Subject: 2026/90831 at location Dam Head Farm, Dam Head Lane, Lepton, Huddersfield, HD8 0NT

Many thanks, Katie
Ecology Team
Planning and Development Service
Place Directorate – Skills and Regeneration
PO Box 1720,
Huddersfield,
HD1 9EL

title
 Plans & Elevations - As Existing

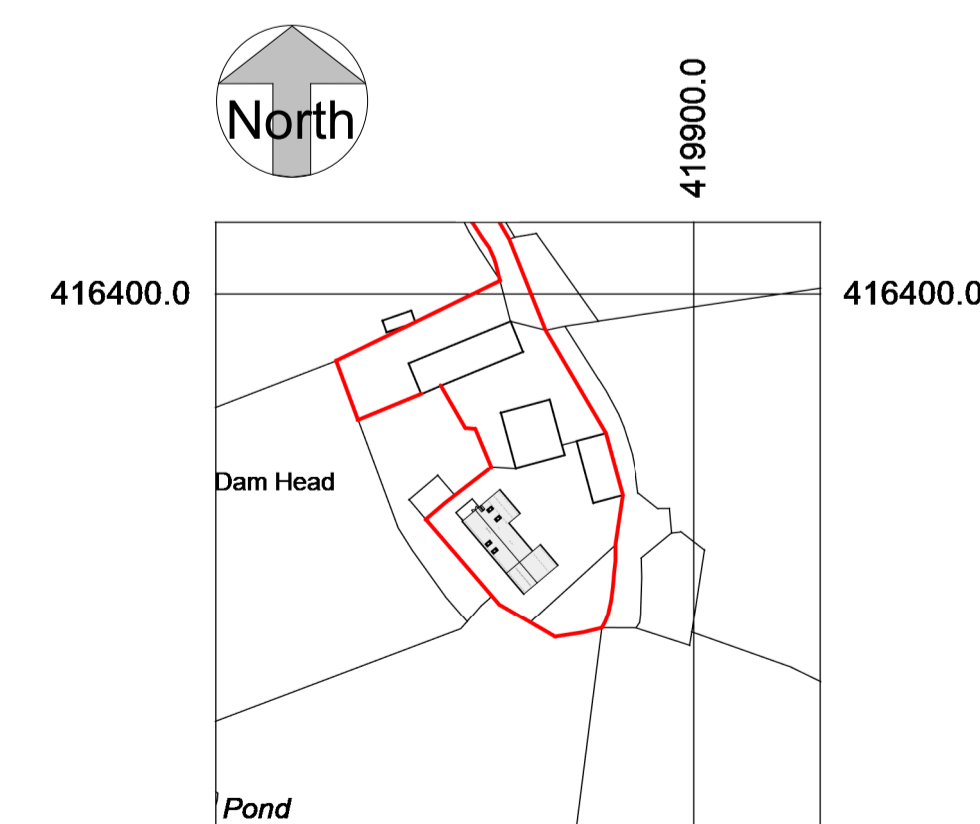
The building to be demolished appears to have features offering suitability for roosting bats and nesting birds. A Preliminary Bat Roost Assessment will need to be conducted prior to determination under Case Law (CO/2820/2008 / 2009 EWHC 1227(Admin)).
